AB/10/20/L

The White House 25A King Street Arundel BN18 9BJ

Listed building consent for the removal of internal spiral staircase from ground floor to basement, reinstating floor, re-opening of original internal brick steps to basement.

GROUND FLOOR LAYOUT

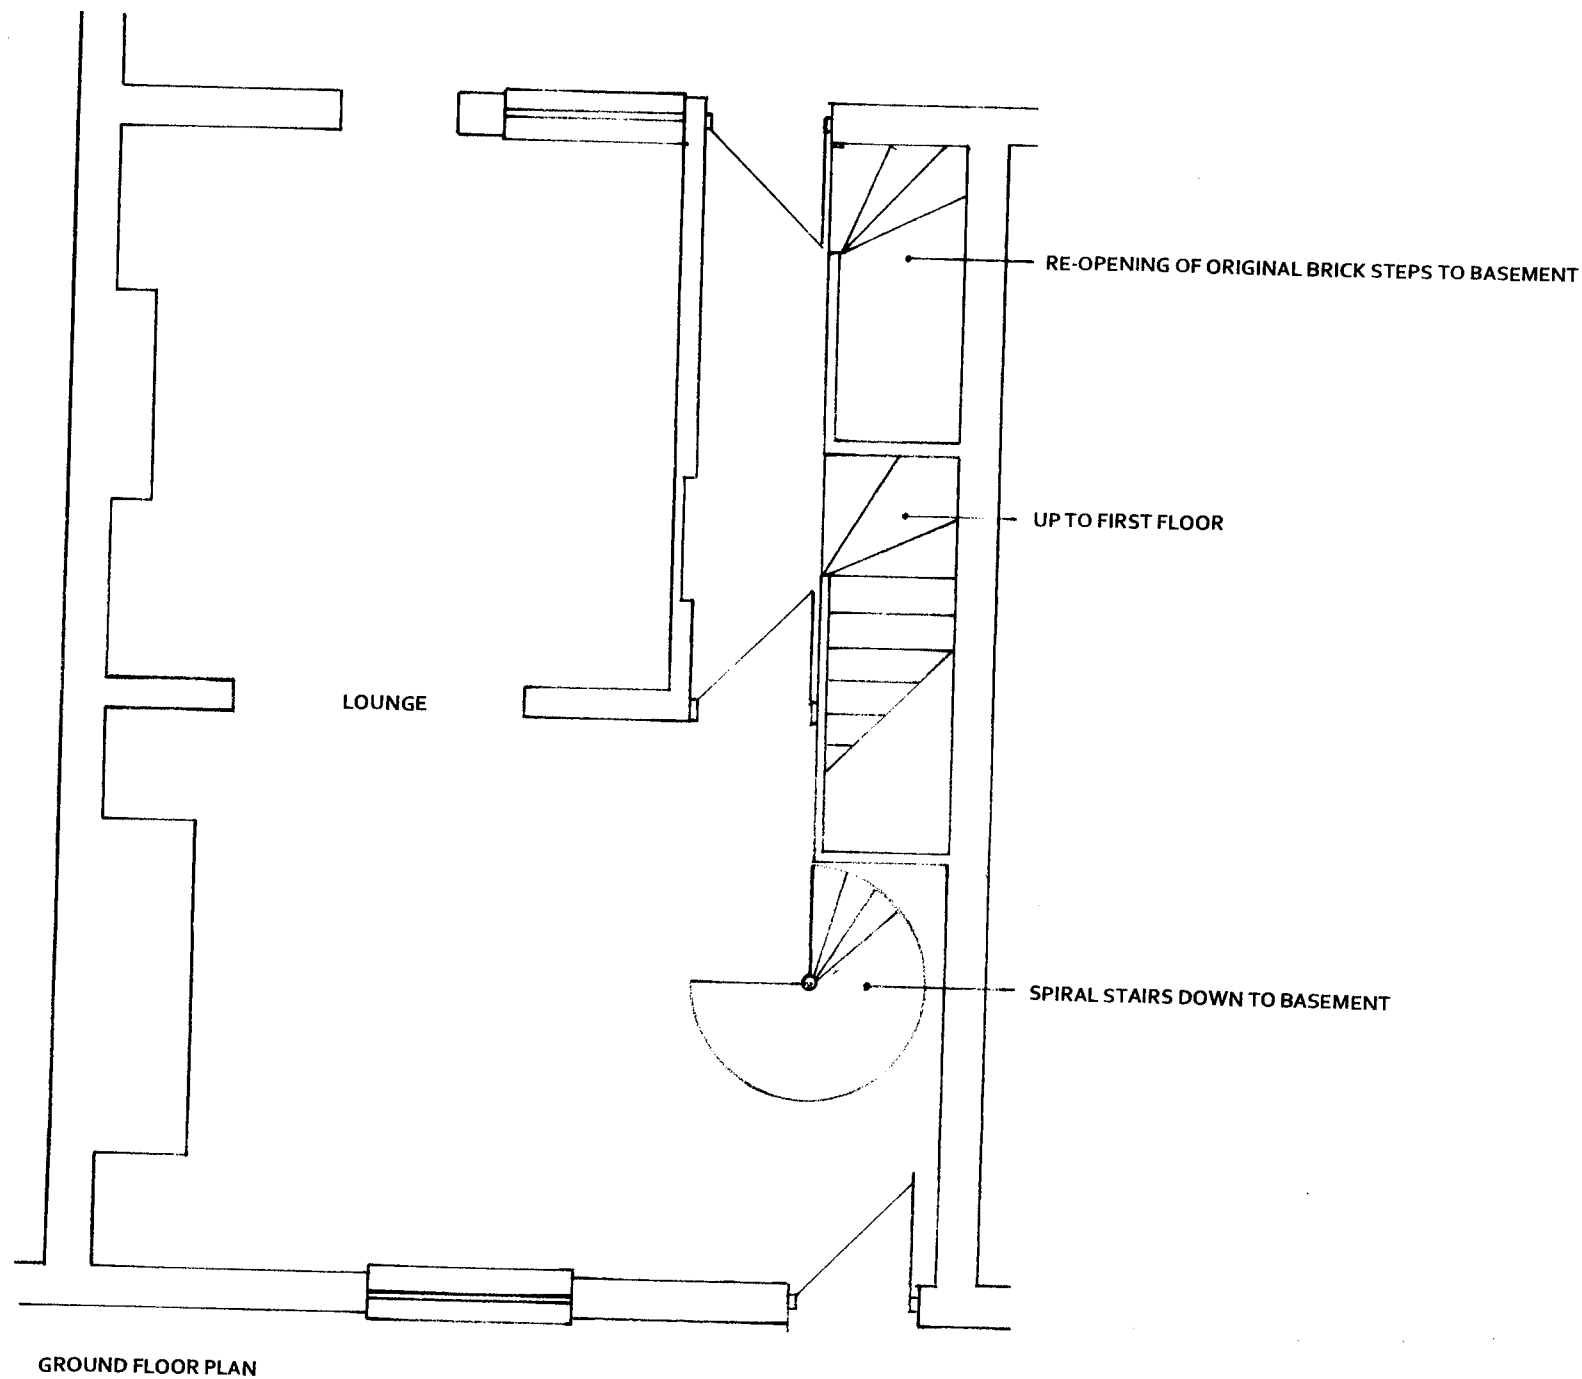
The proposal involves the removal of a modern spiral staircase which is between the ground floor and the basement, reinstating the floor, as well as re-opening of original internal brick steps to basement. These brick steps remain present in the building as indicated by the information provided as part of the application.

The removal of the modern staircase will not result in the loss of any historic fabric, and would result in the use of the traditional basement stairs which remain within the building. Further, such a proposal will allow the original layout of the property to be reinstated.

It is considered that the application will have a positive impact upon the character of the building, and therefore its significance is not harmed. It is therefore capable of support, subject to appropriate materials being used for the reinstated flooring.
